HAYES STRUCTURAL

Date: August 27, 2025

Re: 25-TDM-006.1
Pool House Rafter Attachment
700 Tilghman Rd.
Coats, NC 27521
Permit No.: BRES-2505-0071

At your request, the plans for the pool house under construction at the above referenced property were reviewed to address the rafter attachment.

ROOF FRAMING PLAN

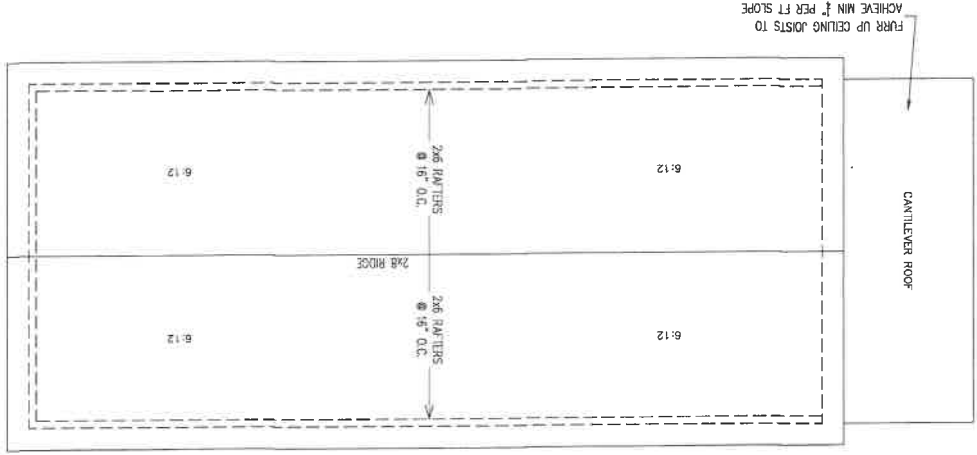
You indicated the rafters were raised after the seats had been cut into the rafters. A +/- 3" tall 2x4 block was fastened to each ceiling joist to support the raised rafter seat. The raised rafters have minimal lapping and attachment to the ceiling joists. A Simpson Strong-Tie H2.5A hurricane tie was installed between each ceiling joist and the double top plate.

Analysis revealed the rafters are not adequately tied to the underlying structure. Install a Simpson Strong-Tie LTS12 twist strap between each raised rafter and the double top plate below. The rafters attached in this prescribed manner will provide the required uplift resistance for all applied lateral loads imposed by ultimate design wind speeds up to 120 mph.
